Tween Bridge Solar Farm

9.9 Statement of Common Ground with Natural England

Document Reference: 9.9

Statement of Common Ground

Figure 1: Non Breeding Bird Mitigation Plan

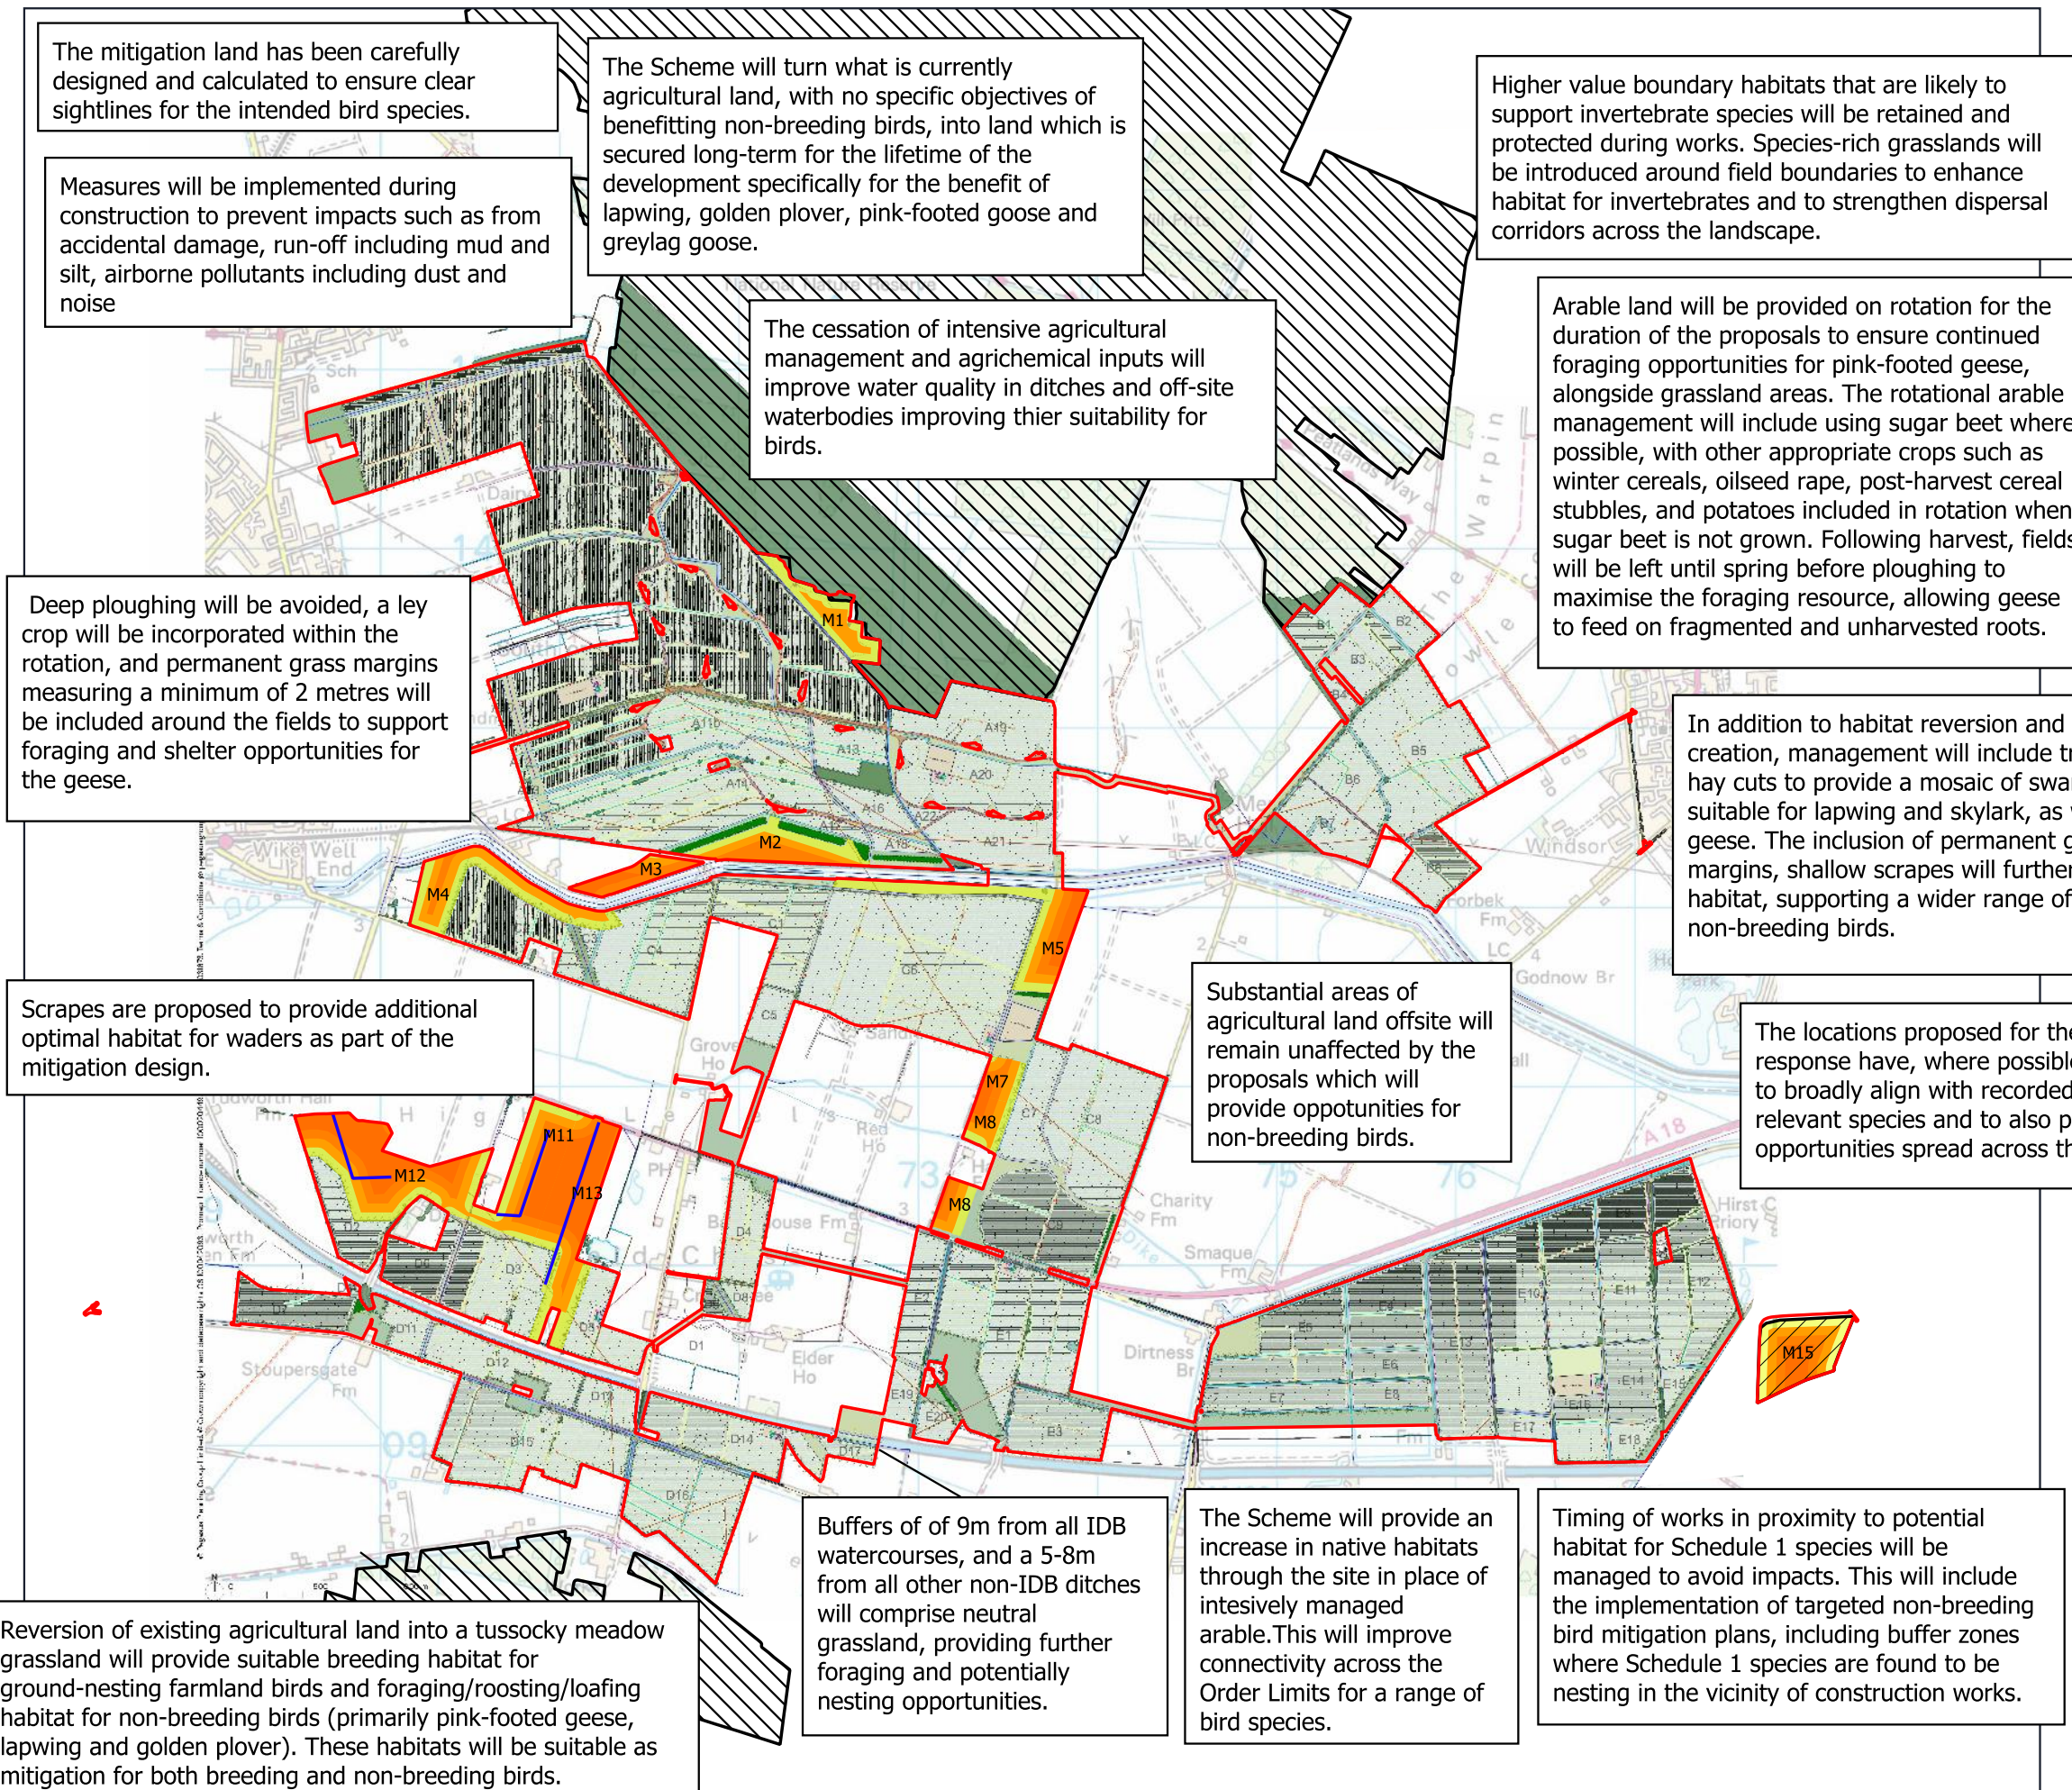
target species, alongside further assessment of connectivity, adjacent habitat, and habitat management (including sward heights and scrape management) within the oLEMP for each of the mitigation parcels. To avoid adverse effects on the integrity of the Humber Estuary SPA/Ramsar, the delivery, monitoring, management and remedial measures of/for all mitigation areas (totalling 183.74 hectares across mitigation areas M1–M5, M7–M8 and M11–M13 and M15) as further detailed in sections 6, 7, 8 and 9 of the oLEMP, must be secured through DCO Requirement 8(2)(a) for at least the operational lifetime of the Scheme. As per 6.22 and 6.23 of the oLEMP, the mitigation areas must be available and functioning prior to construction commencing.	not an SPA qualifying species, although consideration has been given to these species within the mitigation design. The Planning Inspectorate’s Section 51 letter (EN010148, dated 15 August 2025) states that greylag geese are not an SPA qualifying species and that it was not clear why this species was being included within the Report to Inform Habitat Regulations Assessment [Document Reference 5.3 Revision 7]. As such, whilst this species has been considered within the mitigation design as part of a robust approach, mitigation for greylag geese is not required. The Applicant confirms that a full assessment of each parcel has been provided, and includes details on the proposals and management of each parcel. Environmental Statement Appendix 7.10 Non-Breeding Bird Mitigation Strategy [REP4-029] was produced and

Please note that Natural England should only be included as a consultee on monitoring reports where the site is failing its targets. Section 8.5. of the oLEMP states that details of specific remedial measures where the site is failing targets will need to be agreed with the relevant local planning authority (LPA) and Natural England prior to implementation. However, we advise that Natural England will not need to be consulted on these and these should be agreed with the relevant LPA. As previous, all details provided in the outline Non-Breeding Bird Mitigation Strategy (oNBBS) (Rev 7) [REP4-O29] must also be within the oLEMP. In relation to our previous comments about the permissive footpath within mitigation area M1(A), please refer to NE11a for further comments as we consider this aspect a 'yellow' issue (see Part I, page 3 for definition).	submitted at Deadline 1 in this regard. The Applicant confirms that Bird Days calculations have been used as a tool to inform the approximate mitigation area required, alongside ecological knowledge of the carrying capacity of different habitat types. Further detail is provided within the Report to Inform Habitat Regulations Assessment [Document Reference 5.3 Revision 6] updated at Deadline 4. Surveys undertaken demonstrate that golden plover are not a functionally linked species and therefore no species-specific mitigation is required. However, the mitigation areas have been designed to provide open vistas suitable for lapwing, which will also provide suitable habitat for golden plover. Section 2 of the Non-Breeding Bird Mitigation Strategy submitted as Environmental

Statement Appendix 7.10 Non-Breeding Bird Mitigation Strategy [REP4-O29] sets out calculations of land availability with 150 m open vistas, with this information also included within the Report to Inform Habitat Regulations Assessment [Document Reference 5.3 Revision 7] and provided as part of Figure 1 within this document. Several mitigation parcels larger than 10ha with at least 150 m open vistas are provided, including M12 and M13. A total of 43.67ha of mitigation land with 150 m open vistas is located beyond 600 m of wind turbines, in line with point NE3 (see below), and is available for lapwing. Bird Days calculations demonstrate that 24.99 ha is required for lapwing (Appendix 2 of the Report to Inform Habitat Regulations Assessment [Document Reference 5.3 Revision 7]), confirming that more mitigation land is provided than required. Additional	
--	--	--	--	--

mitigation land within 600 m of turbines, including parcels M1 and M2, is also available, and lapwing have been recorded using these areas, therefore ensuring that additional land is available for this species. When considering mitigation land beyond 600 m of turbines, 108.84ha remains available for pink-footed geese and mallard, the remaining functionally linked species recorded within the Order Limits, even when accounting for the 43.67ha provided for lapwing. Bird Days calculations indicate that 22.98 ha is required for pink-footed geese, and as this species forages in similar habitats to lapwing without competing for the same resources, more than sufficient land is provided. Bird Days calculations are not applicable to mallard, as detailed in the Report to Inform Habitat Regulations Assessment [Document Reference 5.3 Revision 7], However, substantial	
--	--	--	--	--

mitigation land remains available beyond 600 m of turbines even after accounting for lapwing and pink-footed geese (85.86 ha), in addition to enhancements to the ditch network which will improve habitat suitability for this species. Table 1.1 provides further detail on the mitigation land calculations. The Applicant confirms that mitigation areas have been selected to reflect bird use where possible. Given the mobility of SPA bird species, and the location of the Order Limits approximately 7.7 km from the Humber Estuary SPA, birds will utilise suitable habitat across a large area. This is supported by non-breeding bird survey results that show use of the Order Limits changed between the survey periods, although also show notable lapwing use in the northern part of the Order Limits close to proposed mitigation areas.	
--	--	--	--	--

The Applicant confirms that the parcel M1 is not proposed to be removed, rather it is proposed to be reduced in extent and would therefore continue to perform a mitigation function for breeding and non-breeding birds. Nonetheless, as detailed in Table 1-1: Non-Breeding Bird Mitigation Land Calculations at the end of this document, the mitigation calculations do not include parcel M1 due to its proximity to wind turbines The Applicant confirms that as seen in Table 1-1: Non-Breeding Bird Mitigation Land Calculations at the end of this document, that the calculations do not include parcel M1 and the figures provided demonstrate there is sufficient mitigation land, based on using Bird Days calculations and the habitat requirements and ecological knowledge of the species being mitigation.	
--	--	--	---	--

The Applicant confirms that 108.84ha is in addition to 43.67ha. As detailed in Table 1-1: Non-Breeding Bird Mitigation Land Calculations at the end of this document, and shown in Figure 1: 16413_P16a_600m Buffers_TLR_RR, at the end of this document. The Applicant confirms that reducing in extent parcel M1 would not affect the mitigation strategy and that sufficient mitigation is provided without the inclusion of M1, based on using Bird Days calculations, the habitat requirements and ecological knowledge of the species being mitigated. Table 1-1: Non-Breeding Bird Mitigation Land Calculations at the end of this document provides further detail on the habitat calculations.	
--	--	--	--	--
